From: Mark Peacock
Sent: 05 January 2017 11:45
To: Planning
Subject: FW: 16/0347/LB Erection of single storey rear extension and internal alterations at The Oshwal Centre, Coopers Green Road, Northaw

From: Andrew Robley
Sent: 05 January 2017 11:40
To: Mark Peacock
Subject: RE: 16/0347/LB Erection of single storey rear extension and internal alterations at The Oshwal Centre, Coopers Green Road, Northaw

The concerns were about the overall size including the width which would mask the only remaining part of the Victorian rear elevation in views from the rear.

DRAWING TITLE  
OSHWAL HOUSE REAR  
EXTENSION-EXISTING AND PROPOSED  
ELEVATIONS

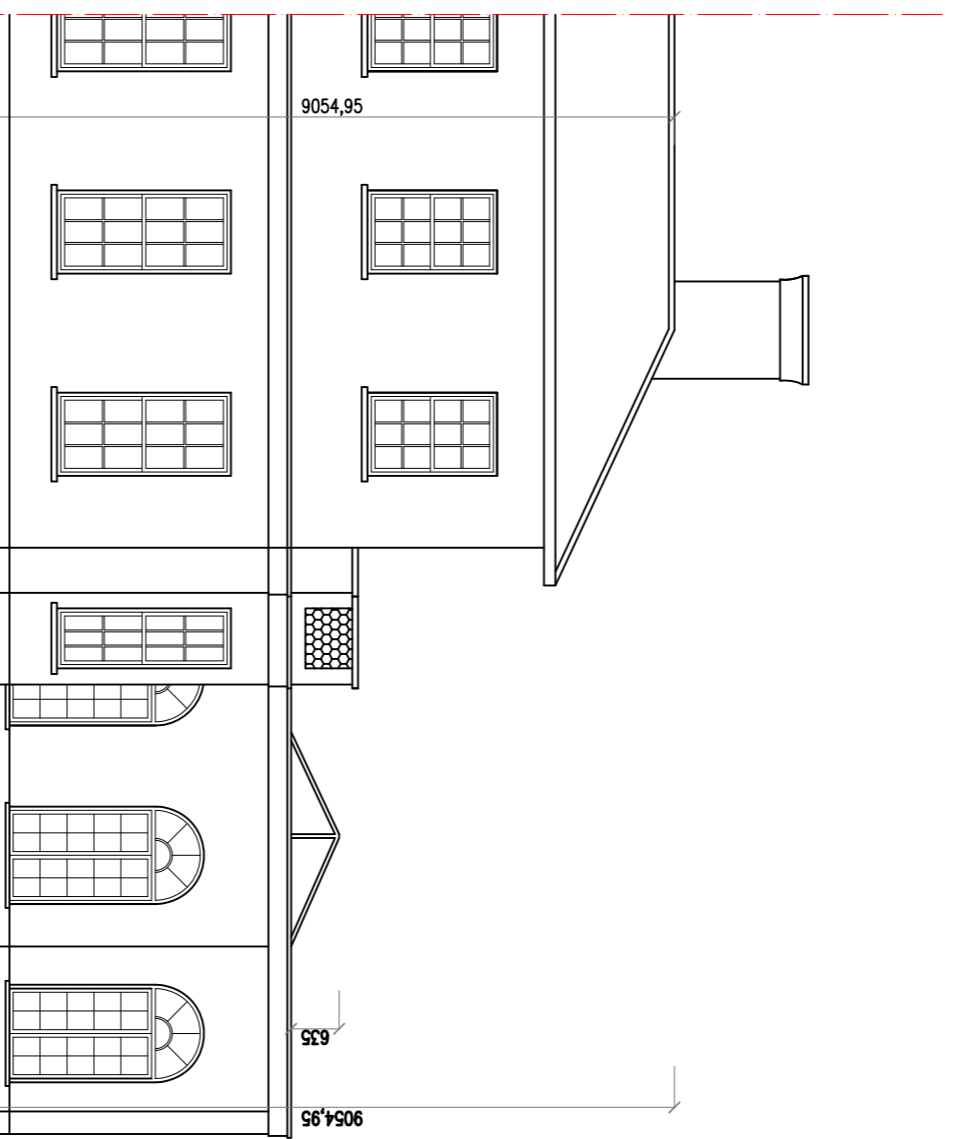
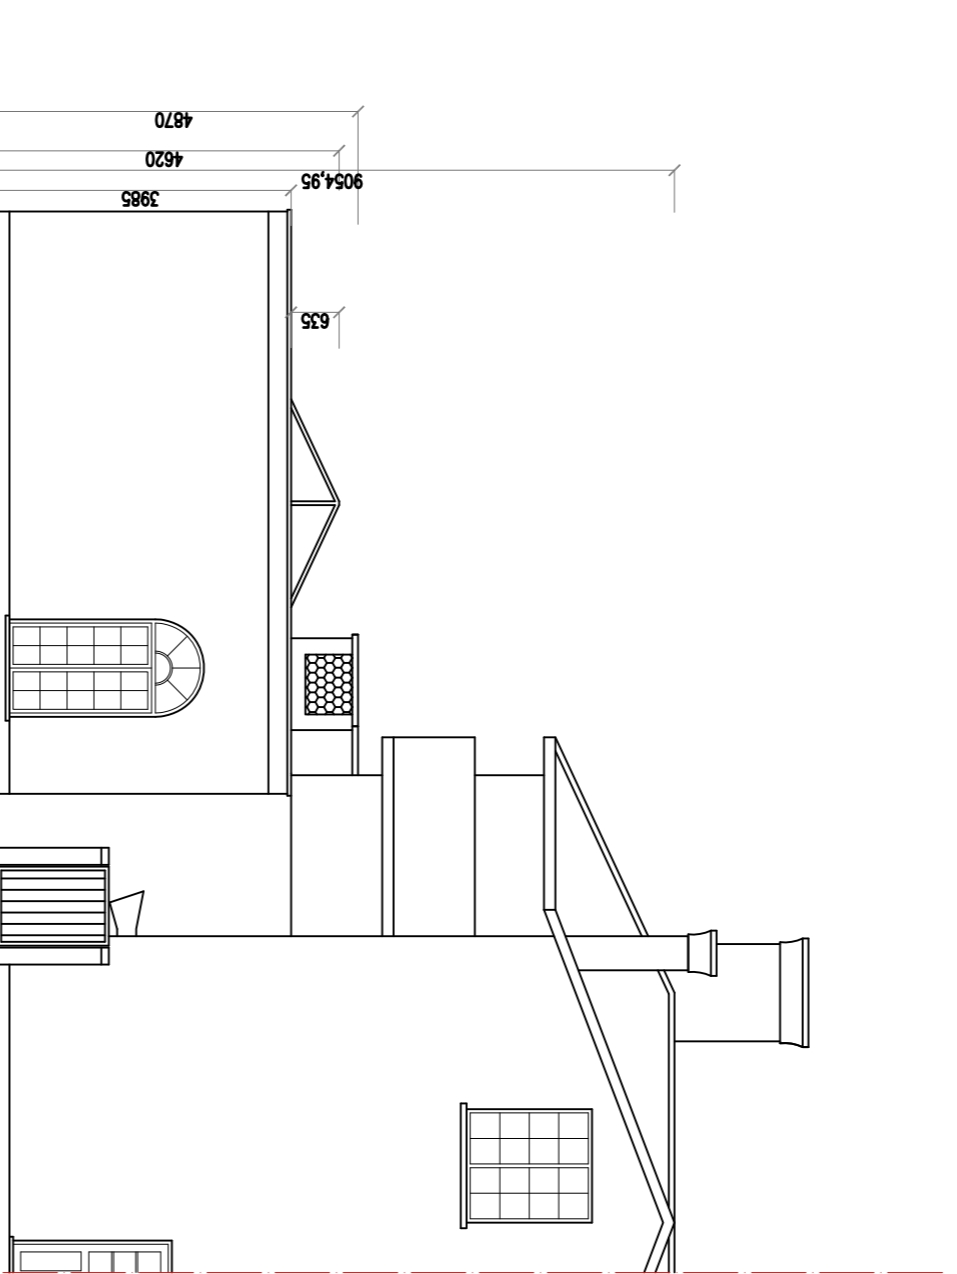
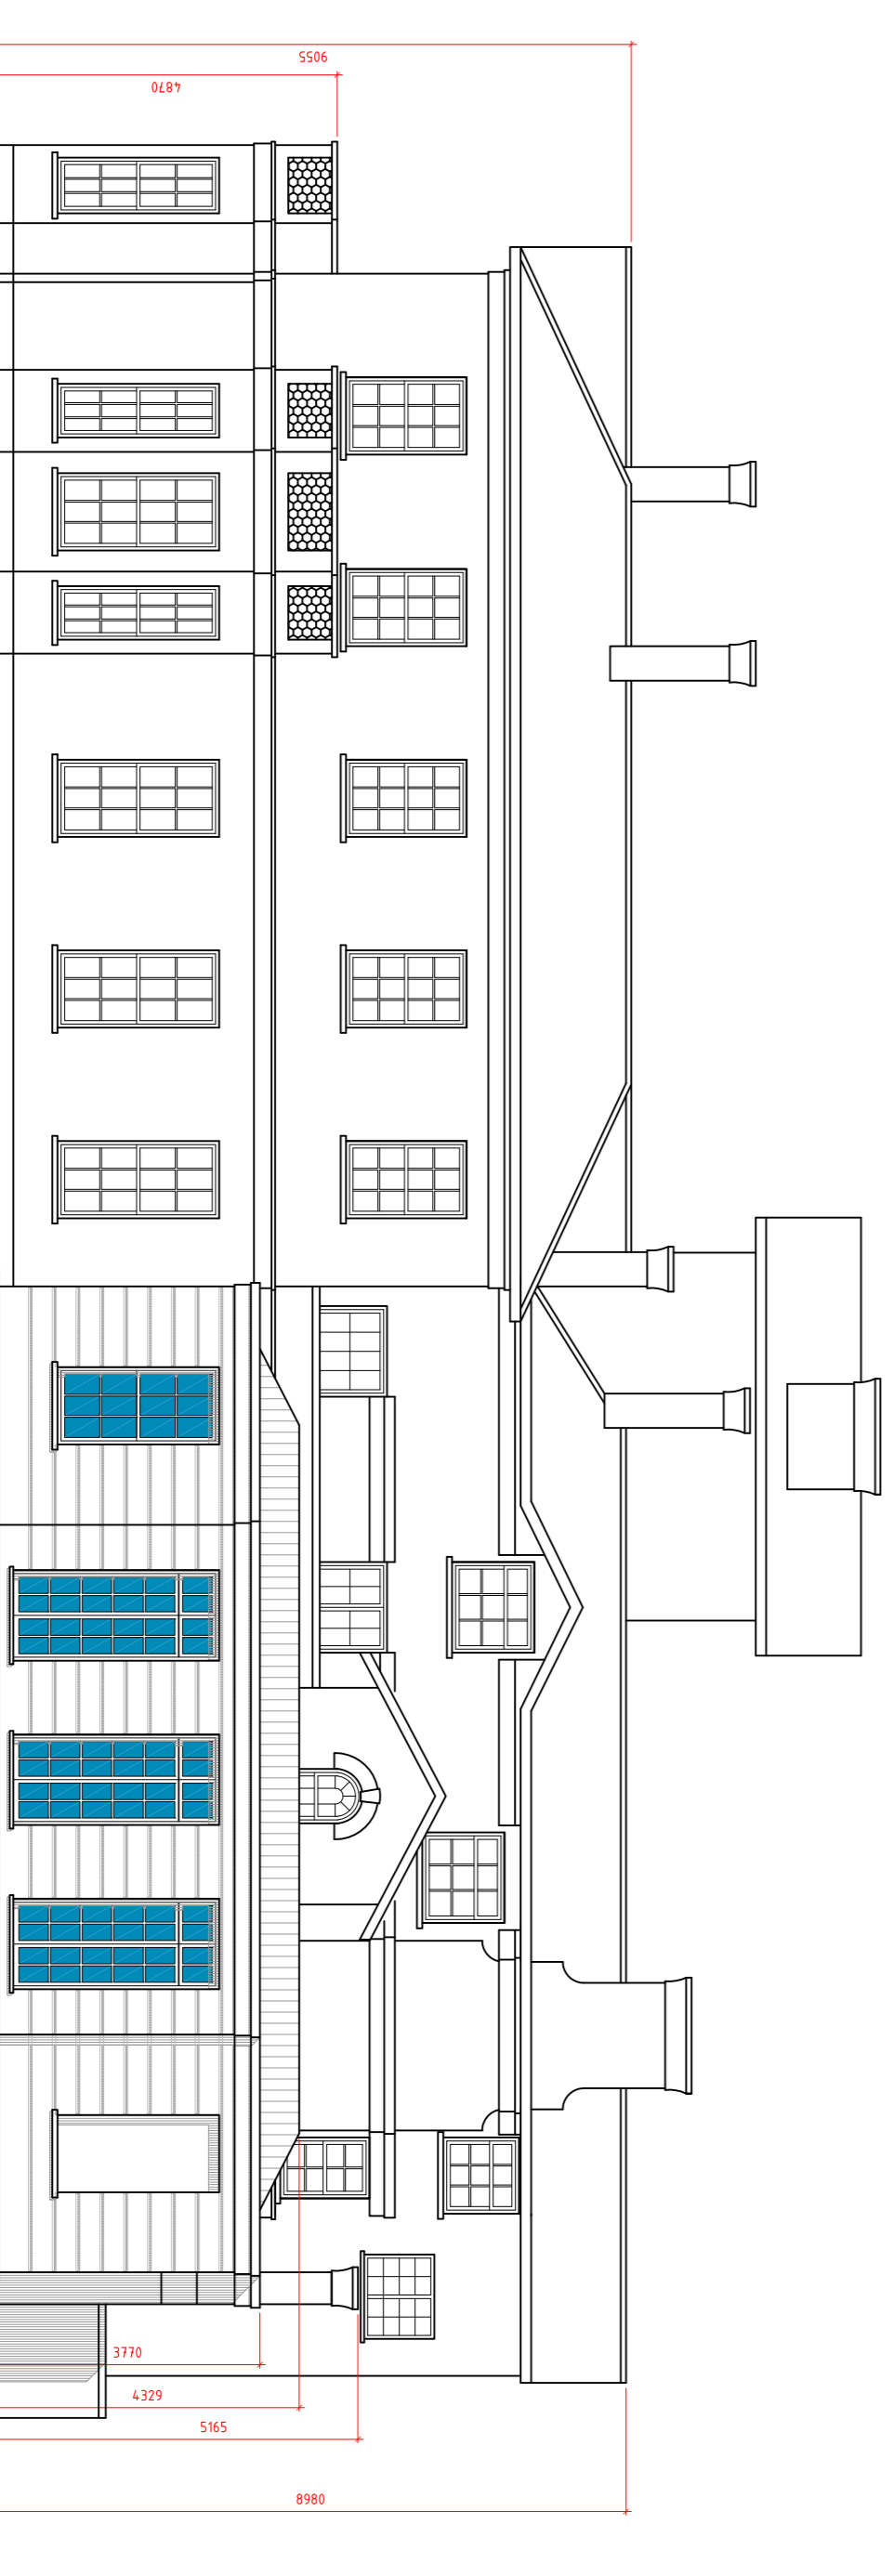
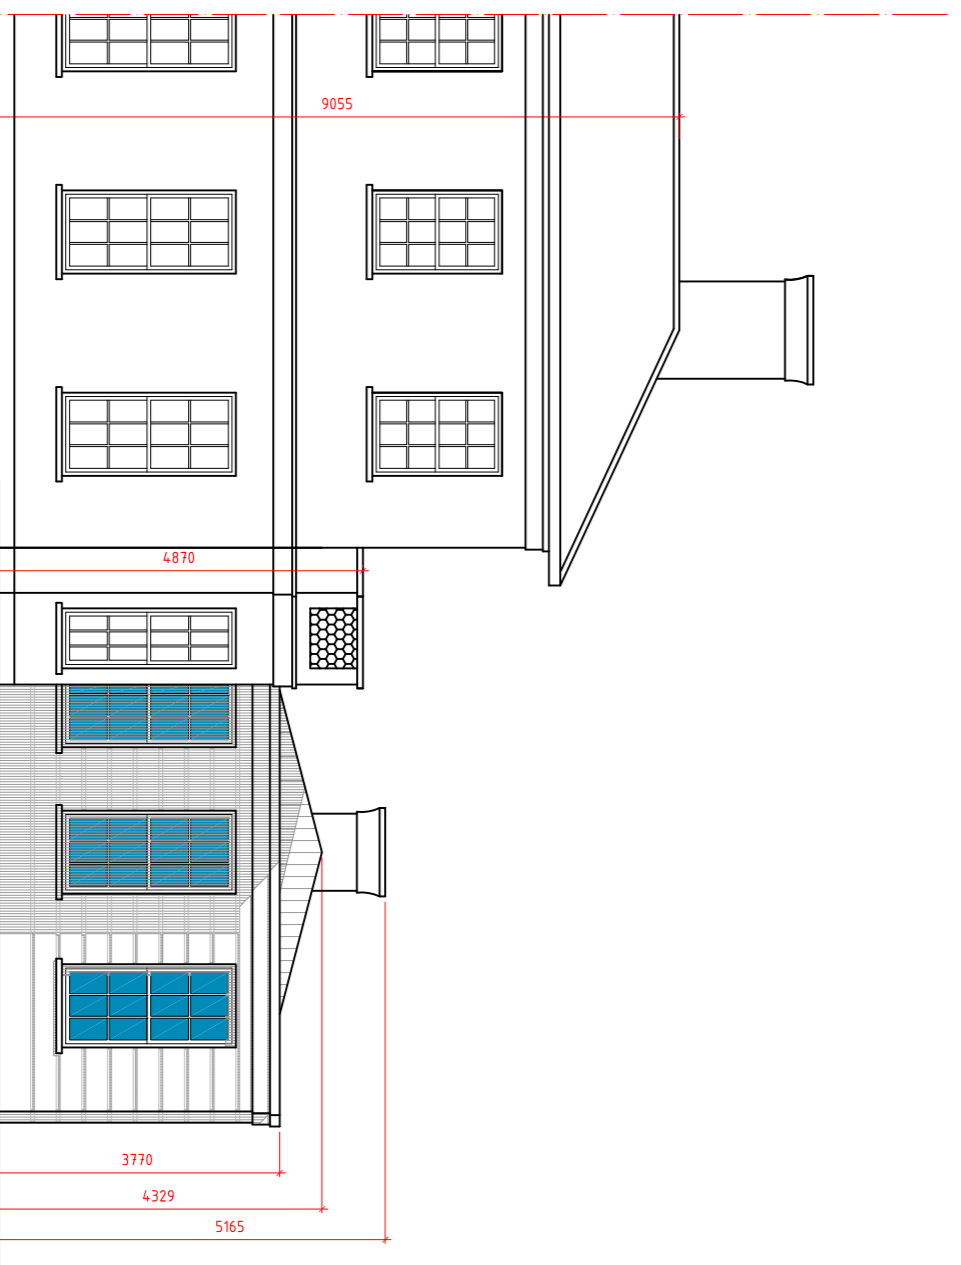
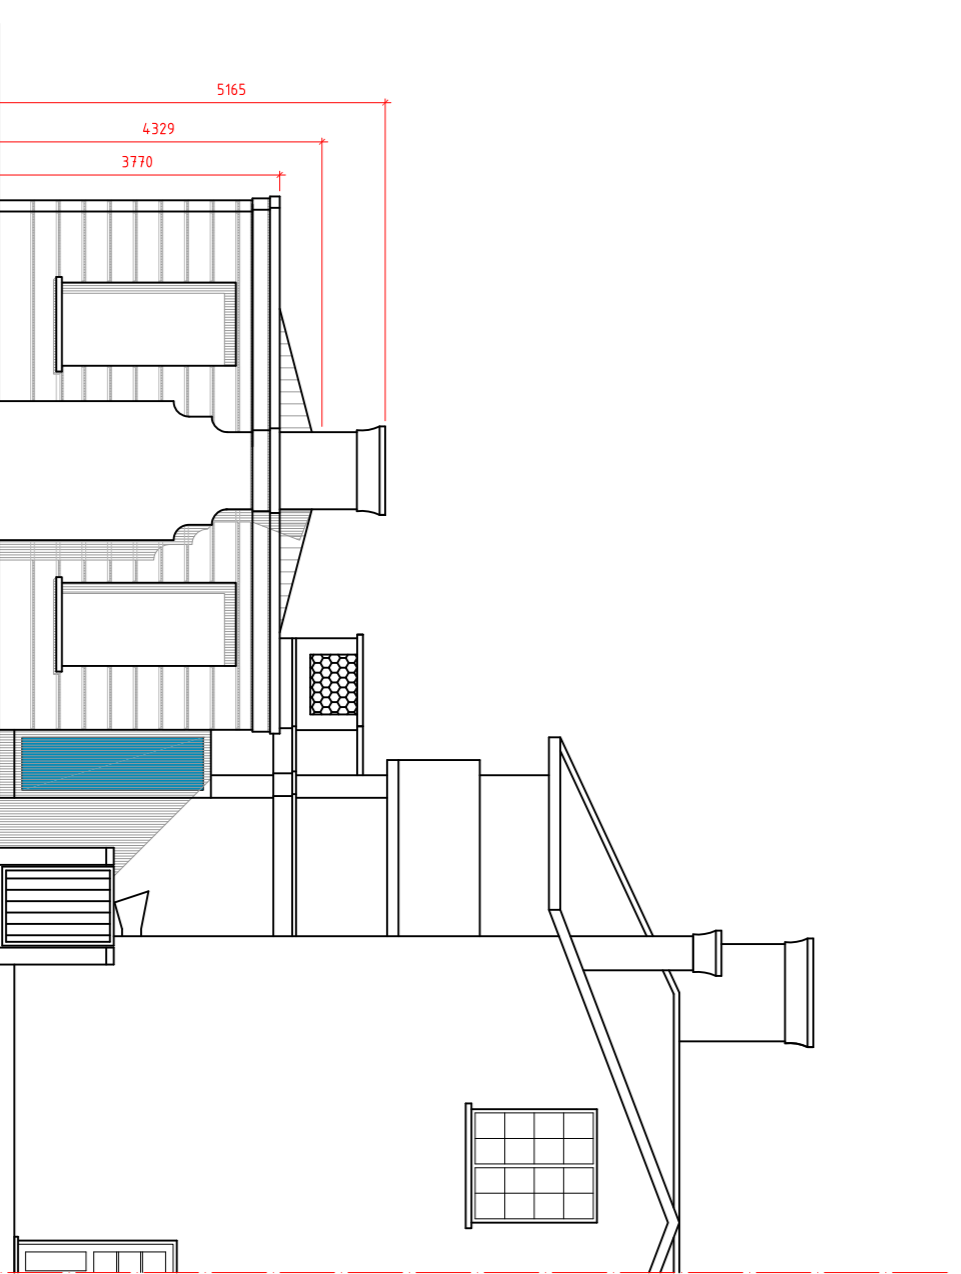
The new proposals do not address this and the introduction of a pitched roof doesn't really work because the plan form is too deep for it to be naturally applied and it would hide yet more of the rear elevation at high level. I also have to say that the design shows no appreciation of the original architecture, especially in the imposition of gable-ended roofs rather than the hipped roofs of the existing. The introduction of the glazed area between the new and the old is not objected to but it has no purpose in addressing the concerns.

The new proposal would extend further by approximately 2.7metres making an overall extension of approximately 8.5 metres. To put this into context, this would approximately double the depth of the original west wing.

The problem with the new proposal is that it would extend completely across the west wing and the "as listed" form of the building would become less distinguishable. Furthermore the area of flat roof, which is essentially out of character with the listed building, would be increased.

Recommendation: As it stands, the proposal would extend too far and would cover up the remainder of the ground floor of the west wing. It would therefore harm the character and appearance of the listed building and its setting, would not now be sufficiently balanced by the community benefit and would not conform to the NPPF 2012 paras 7, 8, 9, 131, 132, 134 and the Local Plan D1, D2, R25.

Further Advice: A large extension was previously approved and it is felt that the perceived form should not extend further than this. It is recommended that the applicant looks at the possibility of housing the kitchens in a basement under the approved extension which would free up more dining space.
